Re: Gundry Solar Farm (SSD-48225958; PAE-77853248) (Goulburn Mulwaree)– Advice on EIS

Thank you for your email dated 14 November 2024 requesting NSW Department of Primary Industries and Regional Development (DPIRD) – Fisheries advice on the publicly exhibited EIS for the Gundry Solar Farm.

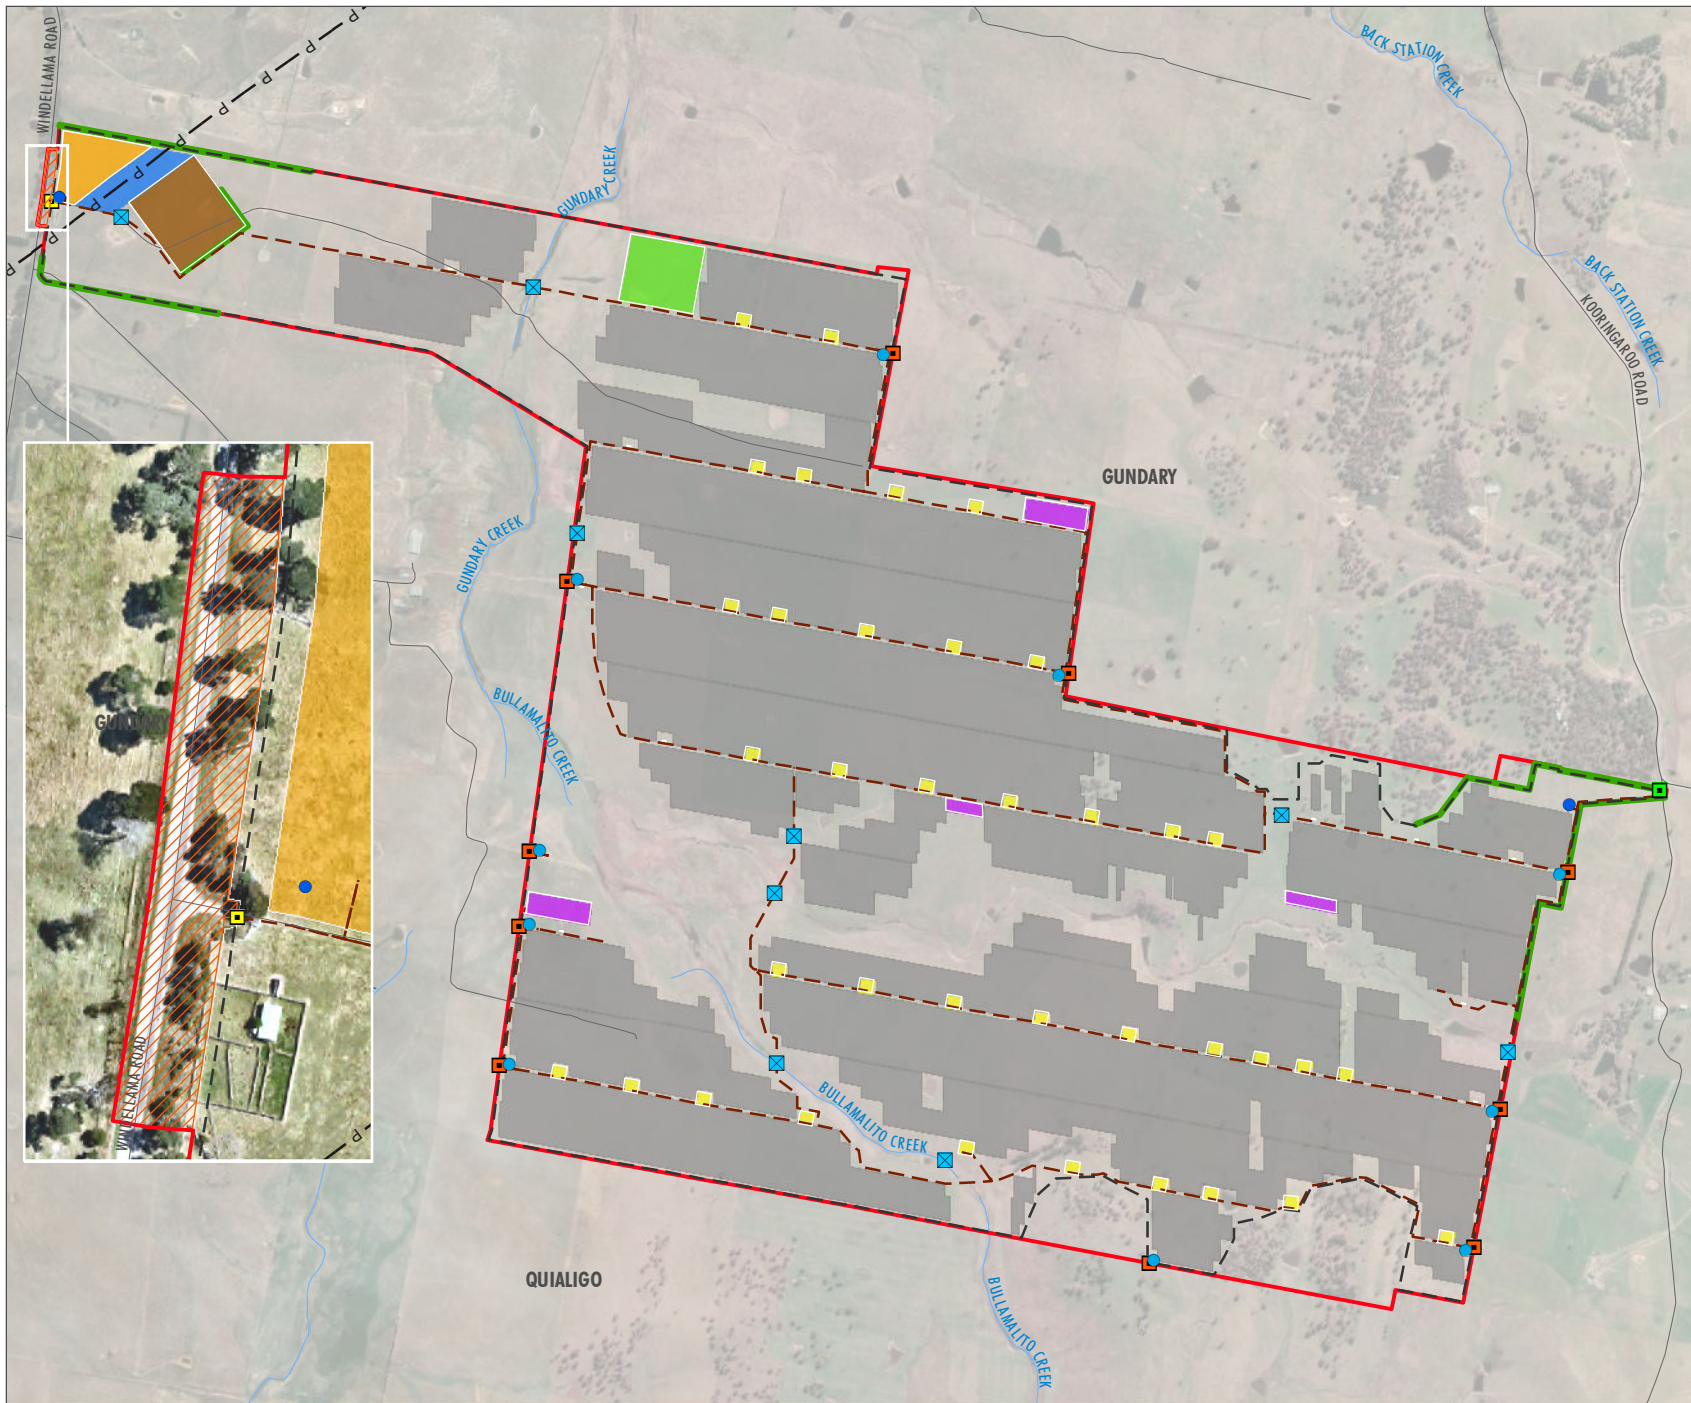
The conceptual layout (Figure ES.2 – Appendix 04) shows three crossings of key fish habitat, all of which are described as Type 3 Class 3 waterways.

The design and construction of all waterway crossings over key fish habitat should be in accordance with the document ‘Why do Fish Need to Cross the Road?’ Fish Passage Requirements for Waterway Crossings (NSW Fisheries 2003) and the Policy (s.4.2), which seek to ensure no new fish passage barriers are constructed in NSW.

To comply with DPIRD Fisheries fish passage requirements, box culverts or bed-level crossings (ford) are the preferred crossing types for these waterways. Box culverts should be designed to

allow for a minimum of 300 mm of water to pool in times of low flow to facilitate fish passage. Bed-level crossings should be designed so the deck of the crossing follows the natural bed elevation and not be perched.

Crossing designs should be provided to DPIRD Fisheries for review at both the concept and detailed design phase to ensure they are consistent with the Policy.
